ADC ref: P/92/11/DOC

Butterlees Barn, Butterlees Farm, LAGNESS
Application P/145/08 – Discharge of Conditions

BUTTERLEES BARN - LHAGNESS
SITE PLAN AS PROPOSED
DWG: BUT/D-01F 1:200 @ A3 JUL 2008
MALCOLM SIMMONDS ARCHITECTS

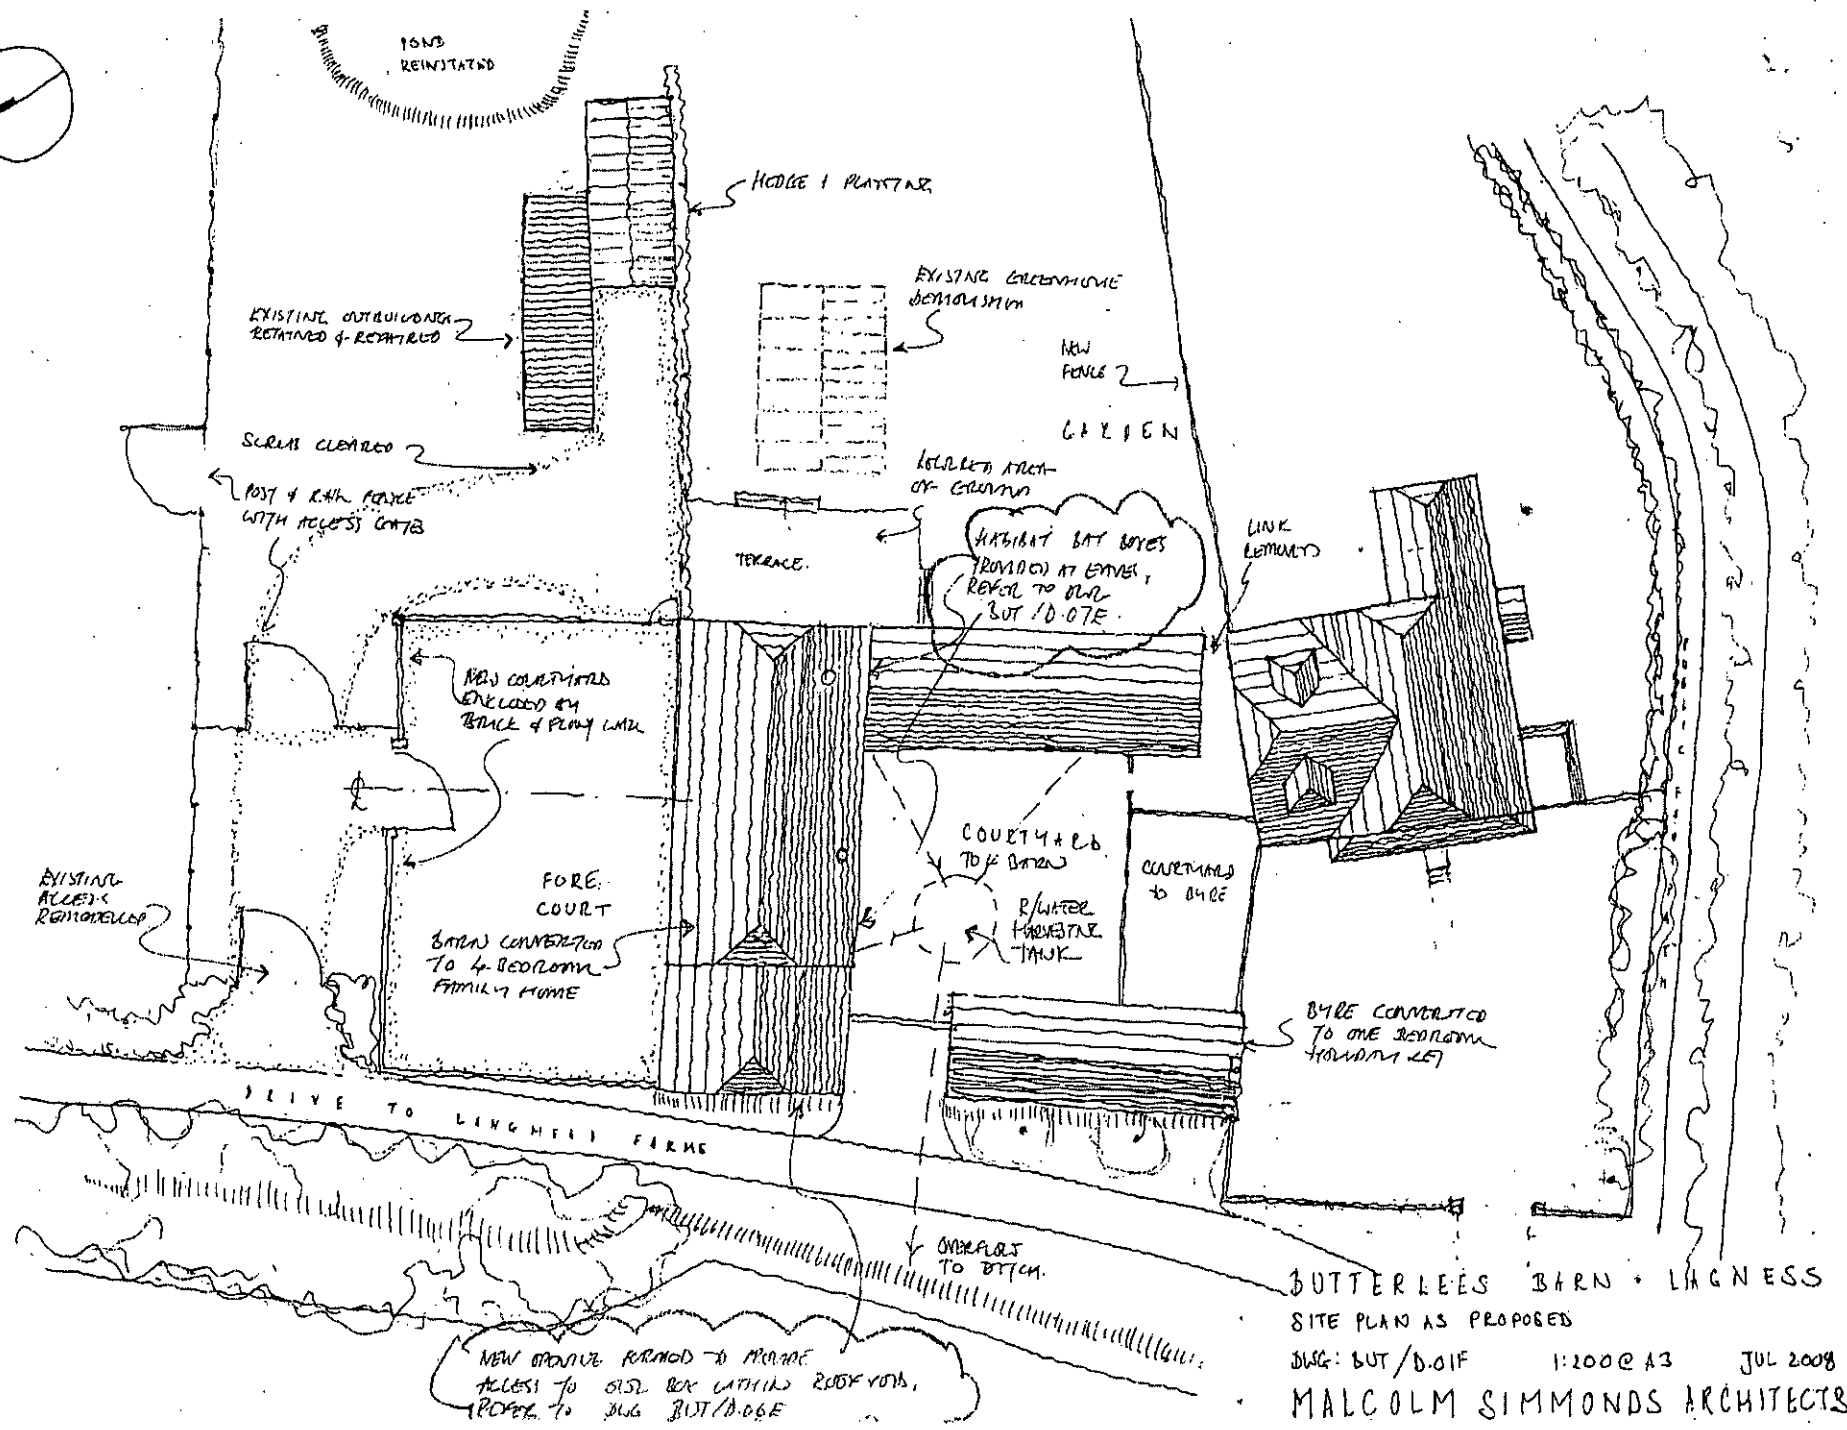
I am happy to defer to Don's specific recommendation over proposed locations of boxes. I do note that Swallow boxes are not included as per the recommendation in the survey report - prefer to see these included.

In summary, two bat boxes have been provided on the preferred south west elevation, these would be Habitat Bat Boxes with a custom brick facing to match the existing building. the owl box would be located on the south west corner of the building facing open fields and built into the building to provide the sort of shelter that Owl's prefer as well as be a discreet addition to the building.
